Application for removal or variation of a condition following grant of
planning permission. Town and Country Planning Act 1990.
Planning (Listed Buildings and Conservation Areas) Act 1990

Number	68
Suffix	
Property name	
Address line 1	Stone Gate
Address line 2	Cowbit
Address line 3	
Town/city	Spalding
Postcode	PE12 6AH

4. Description of the Proposal

Proposed Site Plan (1:250)

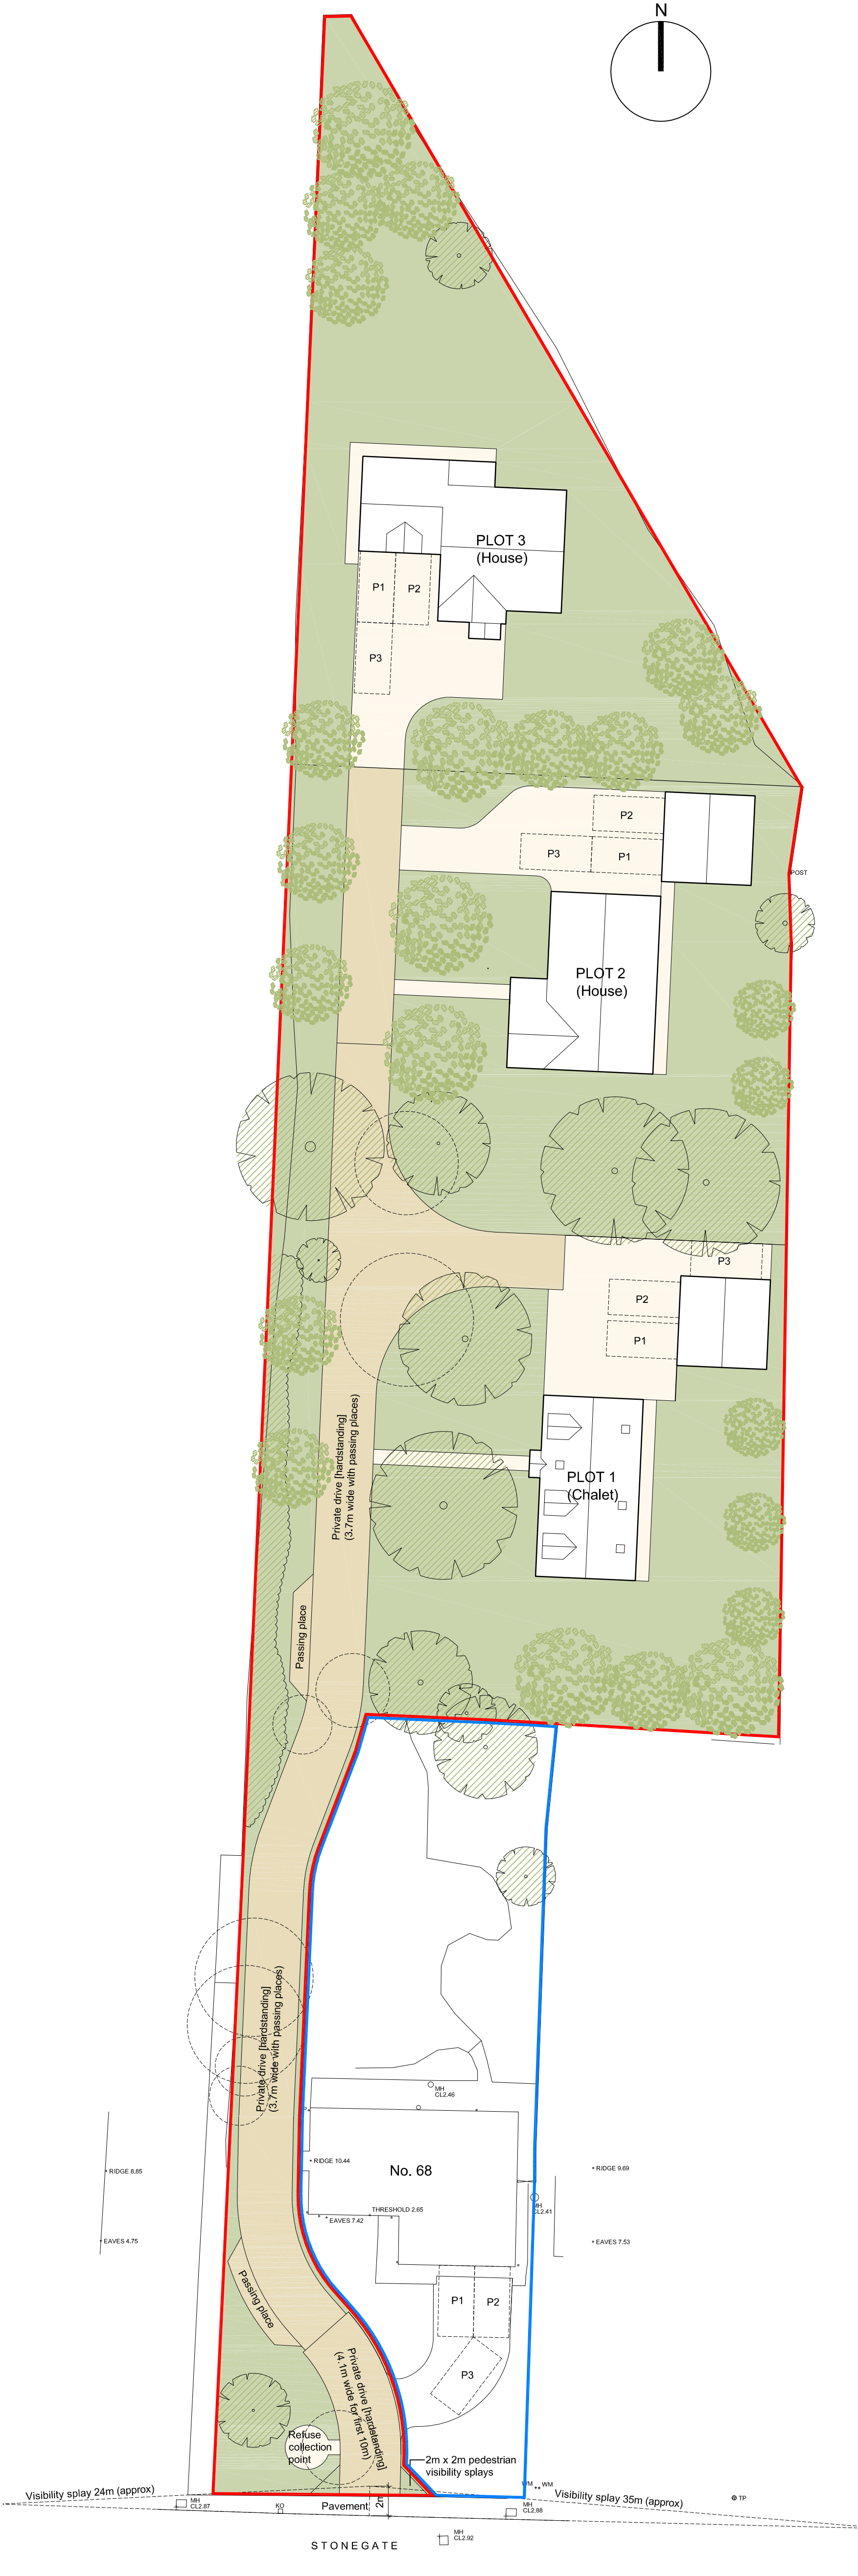
It is requested that the condition be changed. The prescribed visibility splay distance of 43m cannot be achieved here. The agent has liaised with highways officer Jon Sharpe of LCC Highways on 12.10.18 and 23.10.18 via telephone. Having liaised with Jon Sharpe, the agent has undertaken additional survey/design work to establish the maximum achievable visibility splay distances. These are 2m x 37m (to the west) and 2m x 34m (to the east). Jon Sharpe was informed of these distances on 23.10.18 and considered that these are satisfactory in this case.

It is requested that the wording of condition 8 be amended to read as follows:
Notwithstanding the submitted information before the vehicular access is brought into use, visibility splays of 2.0m x 37m (to the west) and 2.0m x 34m (to the east) shall be set-out at the frontage of the site. All obstructions exceeding 0.6m high shall be cleared from the land between the highway boundary and those visibility splays and shall be so maintained at all times thereafter.
